## URBAN DESIGN BRIEF

1052 ST LAURENT BOULEVARD

5 SEPTEMBER 2025

## RESPONSE TO URBAN DESIGN COMMENTS

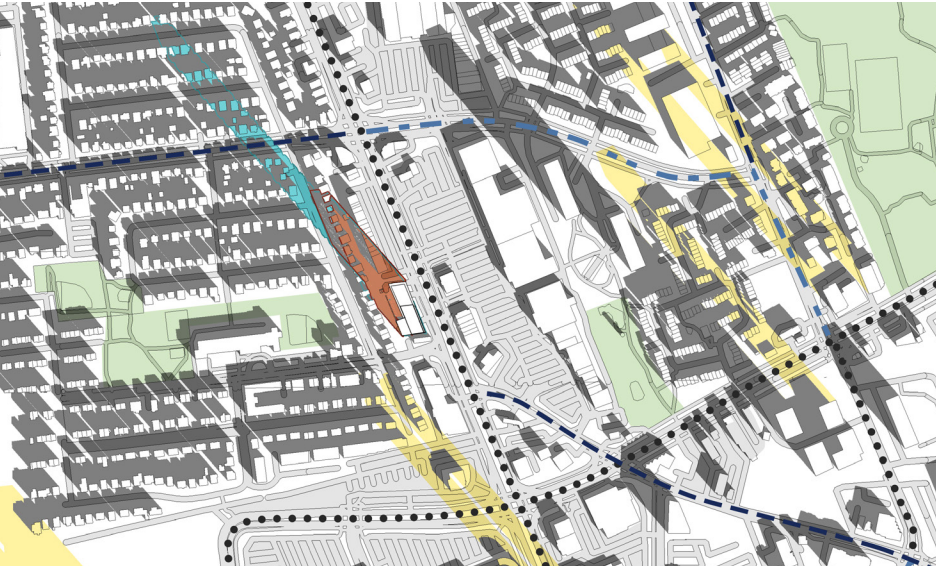
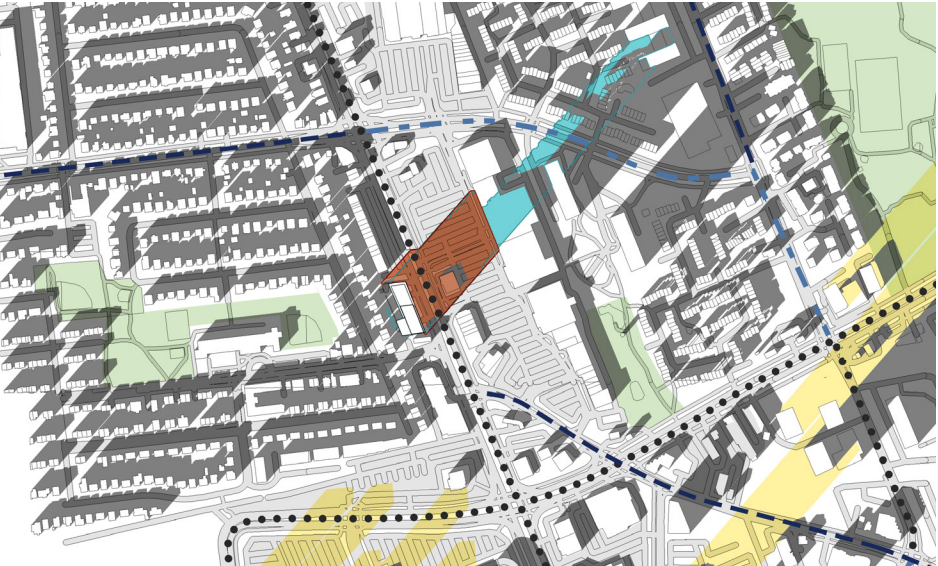
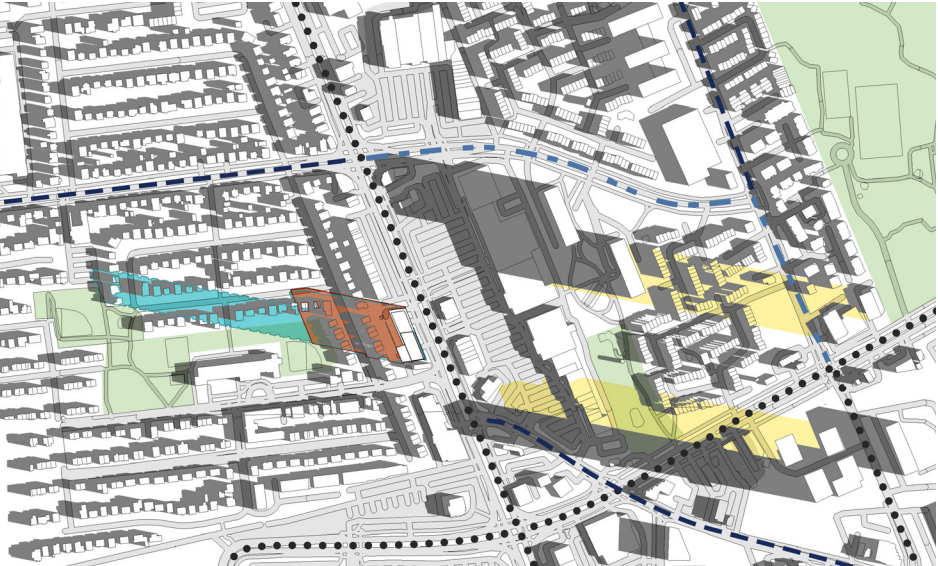
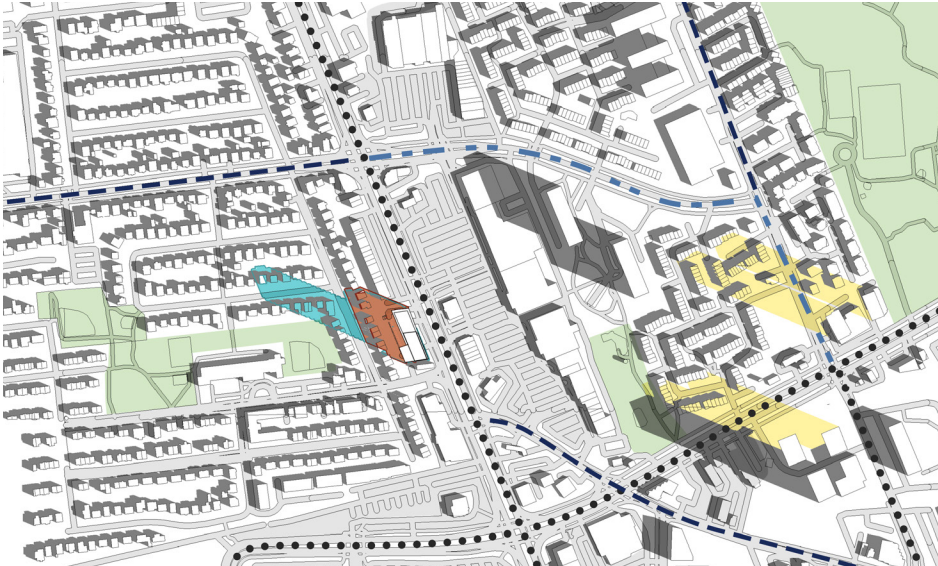
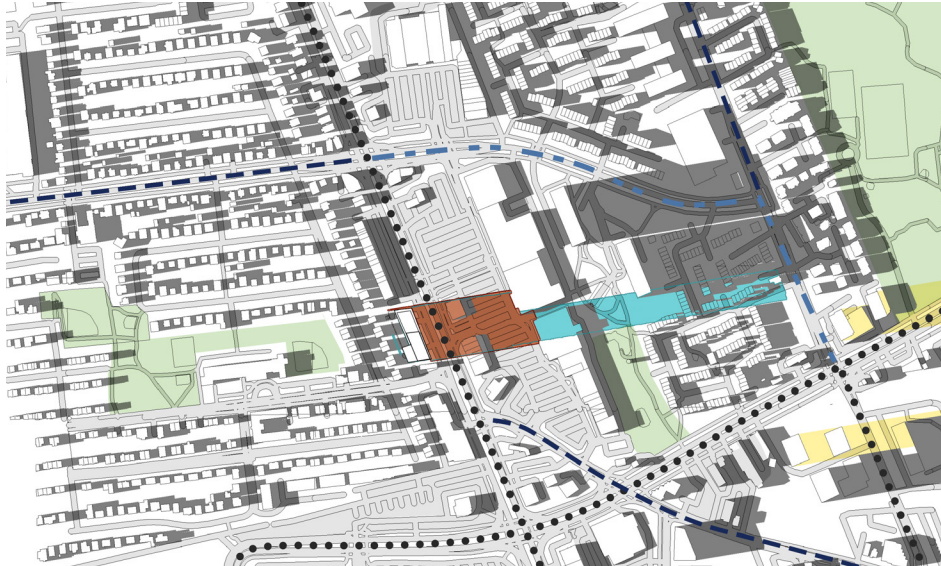
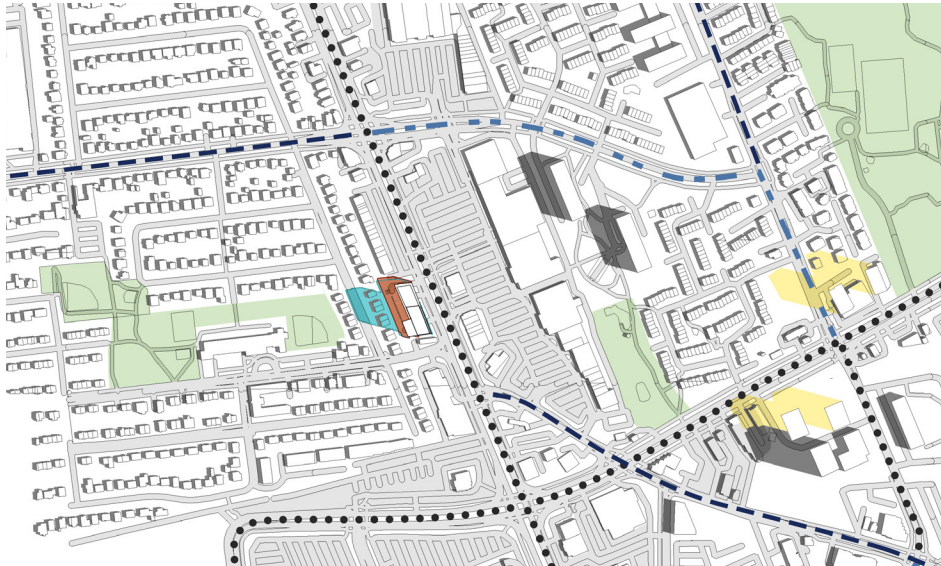
*d. The 9 storey podium also appears very long and would become very impactful to the -lands to the west in casting shadows, as well as on the public right-of-way. A Shadow analysis will be an important tool to evaluate.*

**Please refer to the shadow analysis provided in this UDRP package on pages 36-39.**
